From: Ashleigh Matta <AMatta@parracity.nsw.gov.au>
Sent: Tuesday, 26 May 2015 3:36 PM
To: Fiona Gibson
Subject: Mod 7 - NCA/23/2010 - 330 Church Street Parramatta

Council Officers have reviewed the plans and documentation in regards to MOD 7 for NCA/23/2010. We attempted to meet with Meriton this week, however this fell through.

ELEVATIONS - WEST TOWER

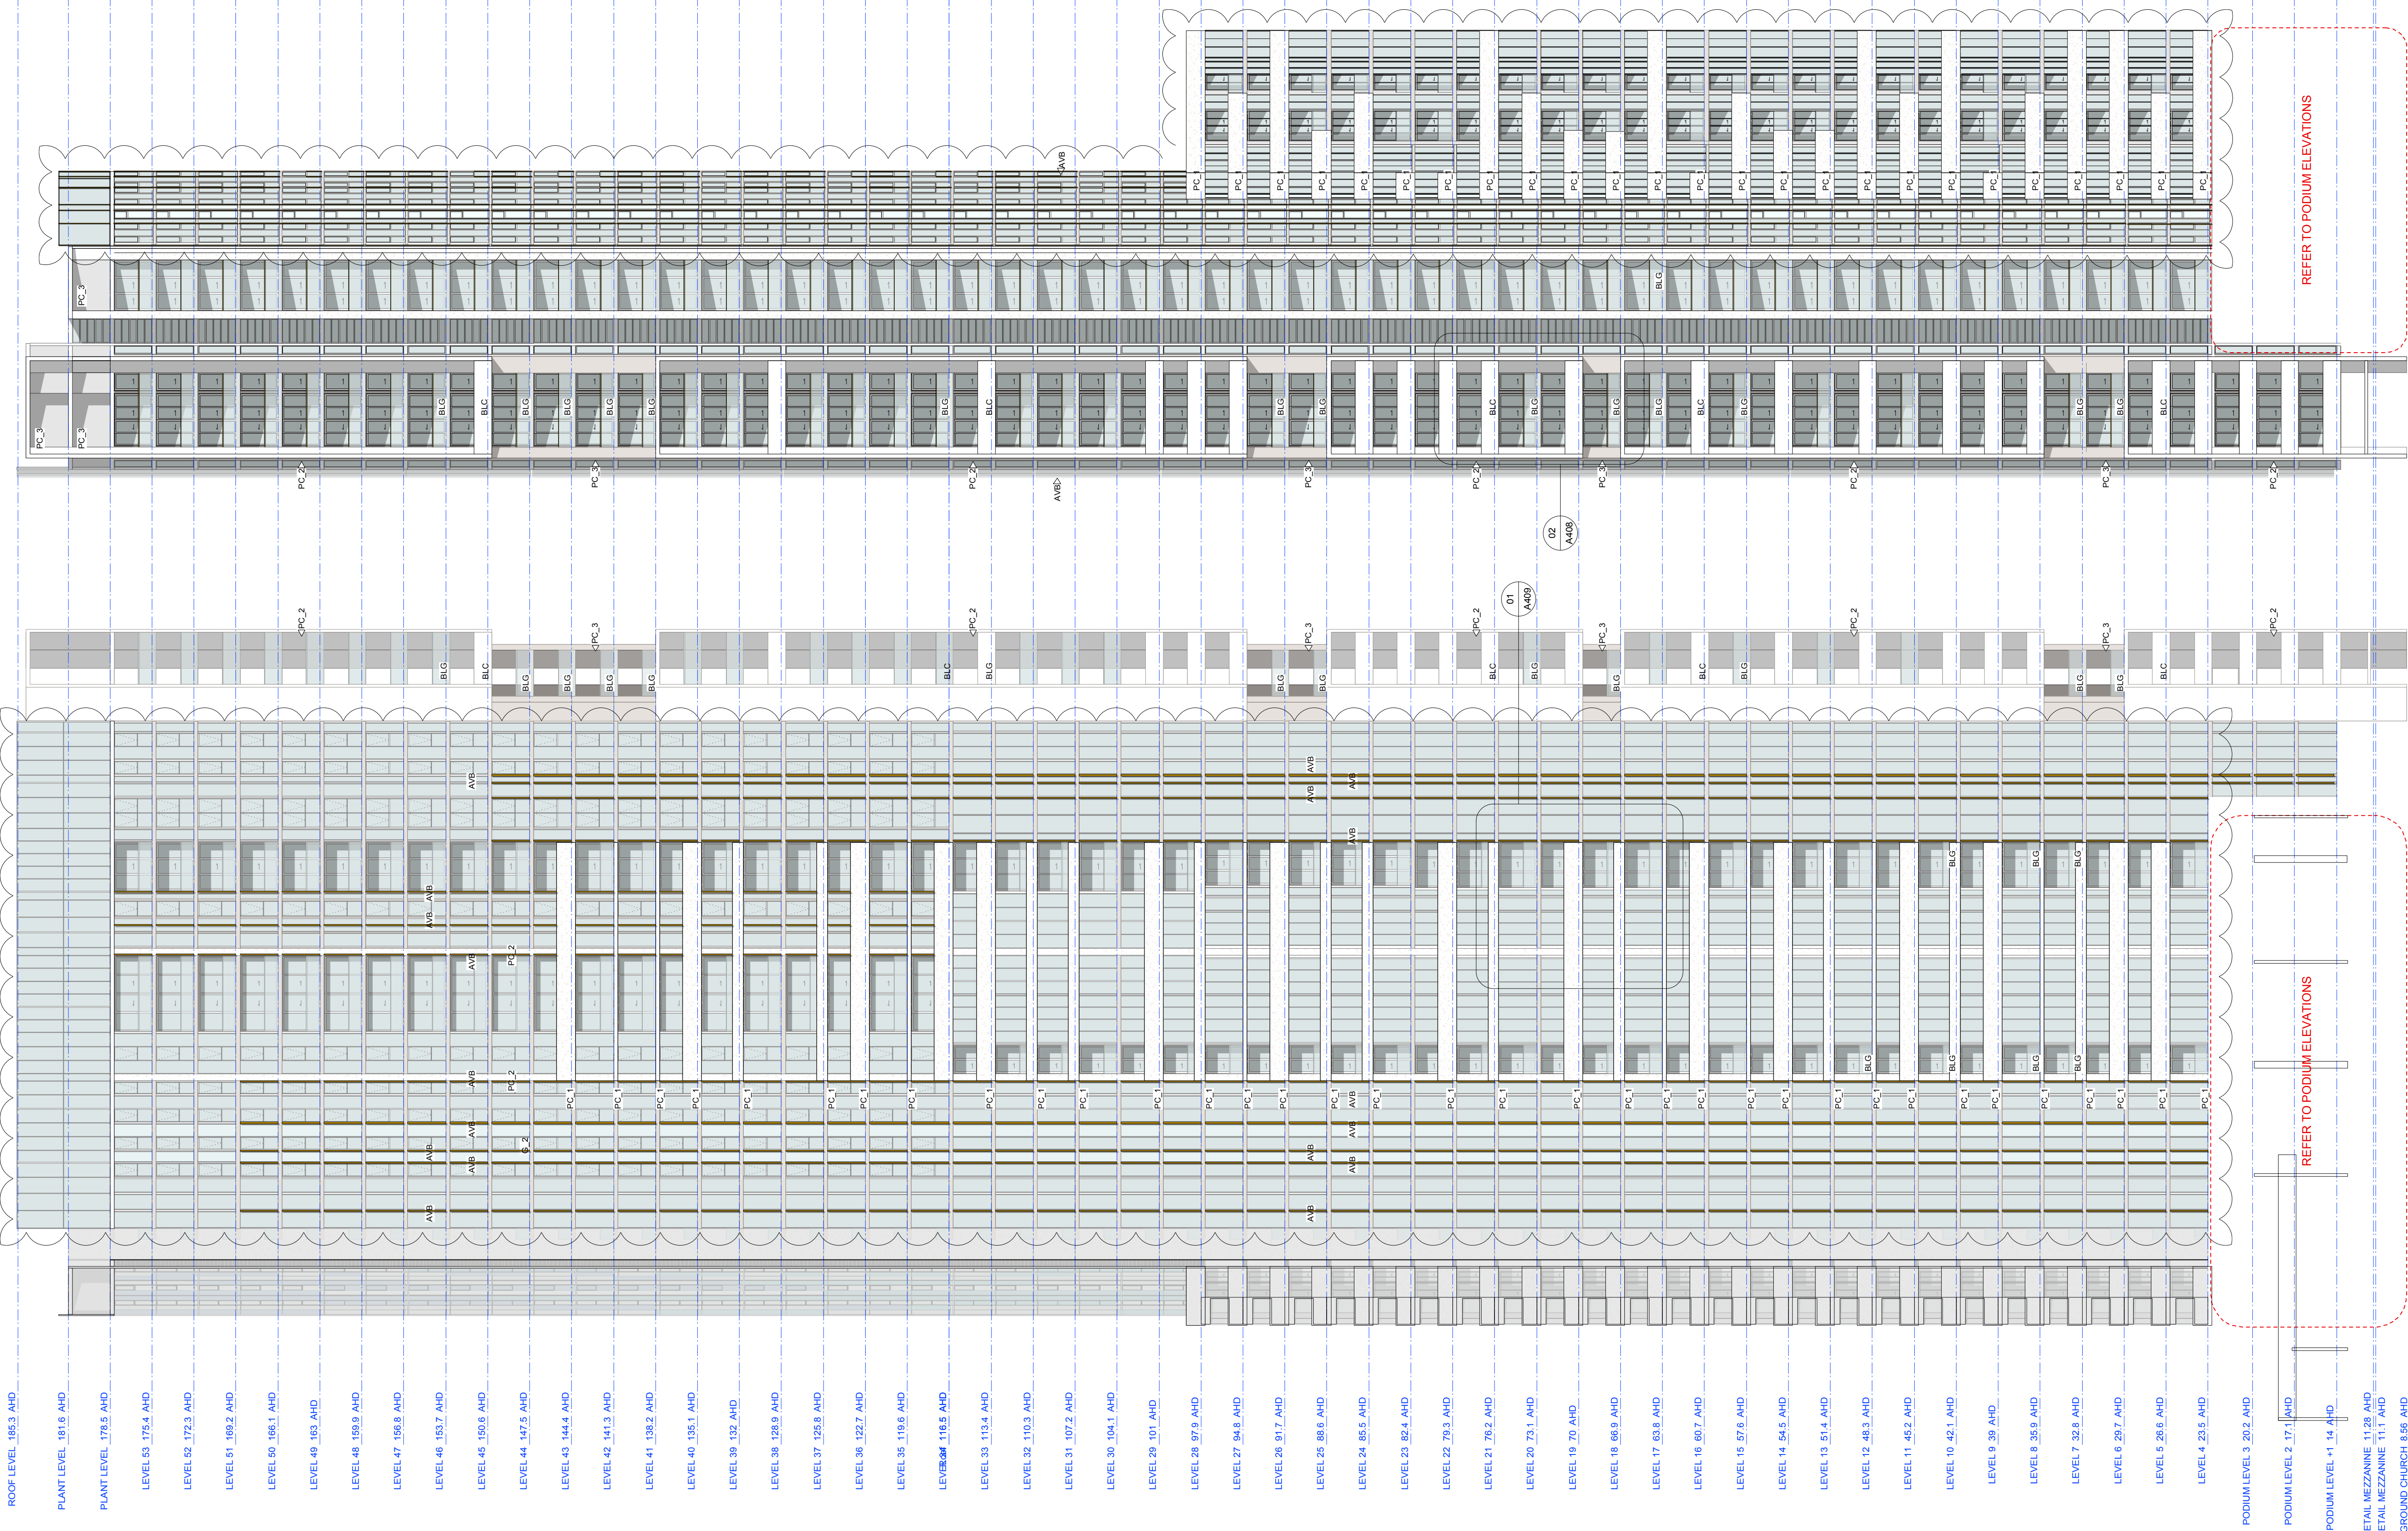
The perspectives of the approved and proposed towers do not provide a clear understanding of the effects of proposal, and the drawings also lack clarity in this regard. It is difficult to fully understand the detail of what is being proposed.

What is apparent, however, from the information provided, is that the architectural quality of the towers would be compromised by the proposed changes. An area of the facades with an orchestrated filigree of detail, depth and shadow has been reduced to relatively unrefined, bland and flat surfaces made up of what seem to be exposed slab edges with infill glass.
